# CITY OF ALBUQUERQUE

November 30, 2015

**RE: Montoya Street Townhomes (File: H12D019A)**  
**Tracts A1 and A2 Lands of David Maciel**  
**Montoya St NW between Floral Rd and I-40**  
**Grading Plan and Drainage Report**  
**Engineer's Stamp Date – 10/15/15**

TRACTS A-1 AND A-2 LAND OF DAVID MACIEL

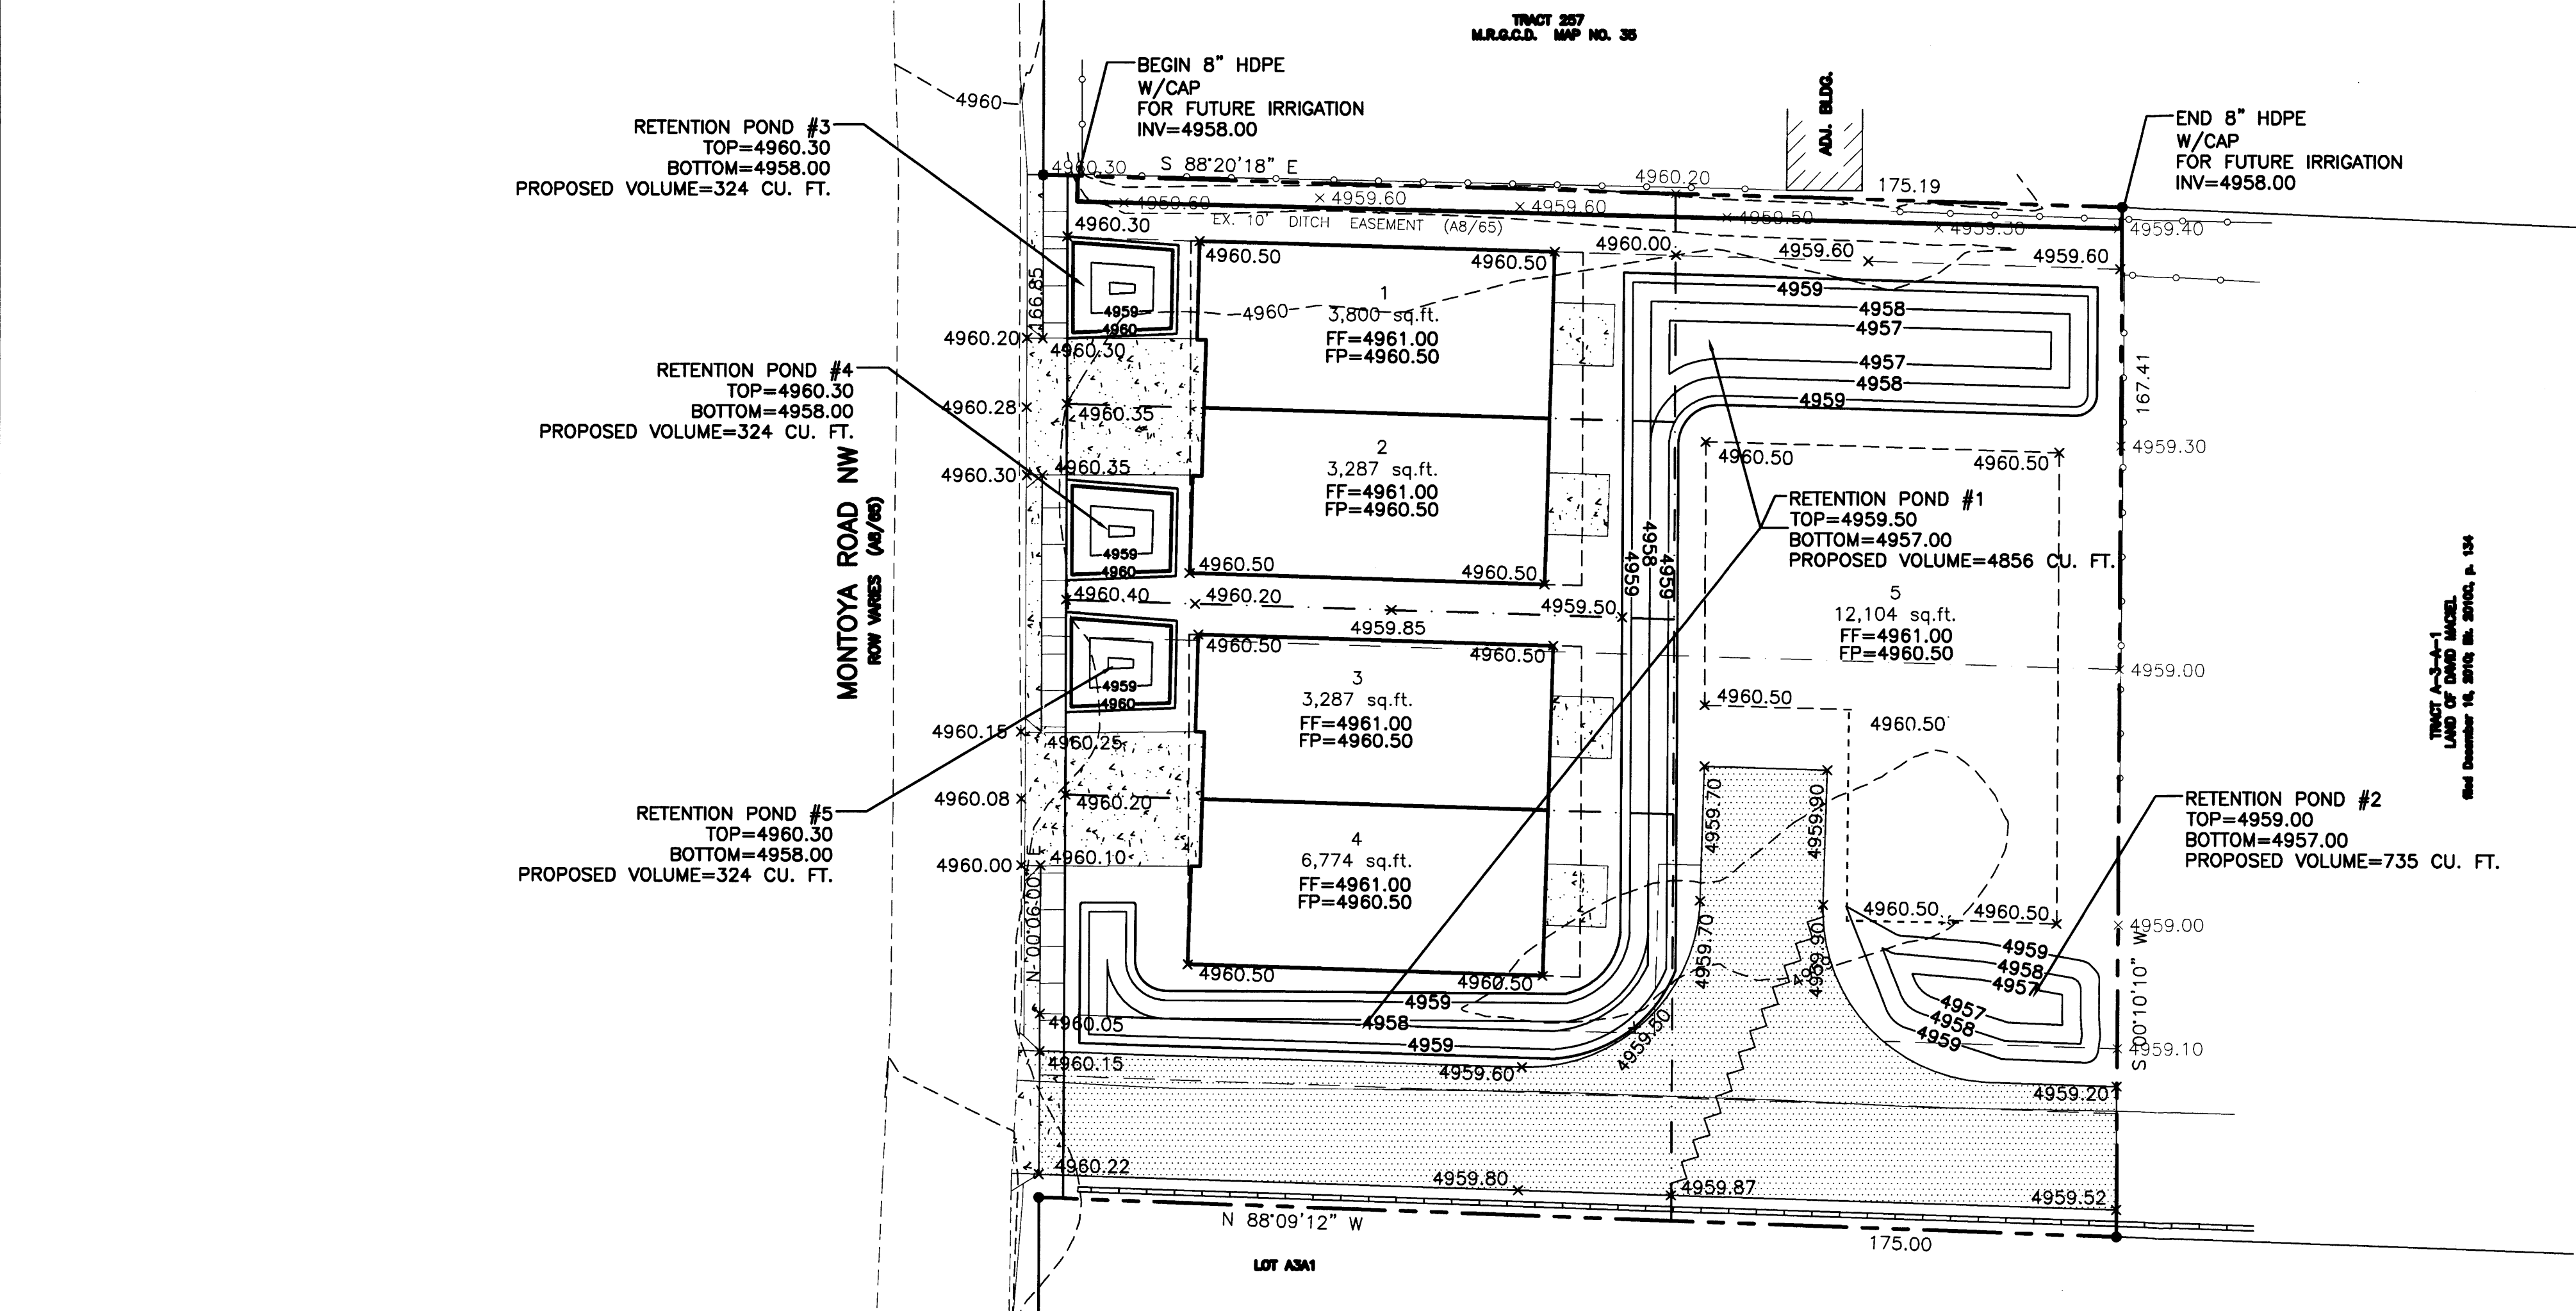
- Provide drainage flow areas to better identify overall site drainage patterns.
- Provide roof flow direction and outfall locations.
- Clearly identify and define property lines.

- Clearly identify the location and limits of the 10 ft Ditch Easement located on the north property line.
- The Drainage Report indicates flows from a storm event exceeding the 100-yr, 6 hr storm event will discharge to Montoya Street. Per the spot elevations identified on the Grading Plan, it appears flows will be directed east away from Montoya Street. Show on the Grading Plan how this will be achieved.

- The Drainage Report states the platting action will allow for cross lot drainage easement on all parcels yet the Drainage Report identifies flows to be retained onsite or discharged onto Montoya Street during a larger design storm. Provide offsite flow information and how offsite flows will be managed onsite.

- A scale check on the area for townhomes 1-5 appears as though the area provided is incorrect. Re-check the areas to ensure the information is correct.
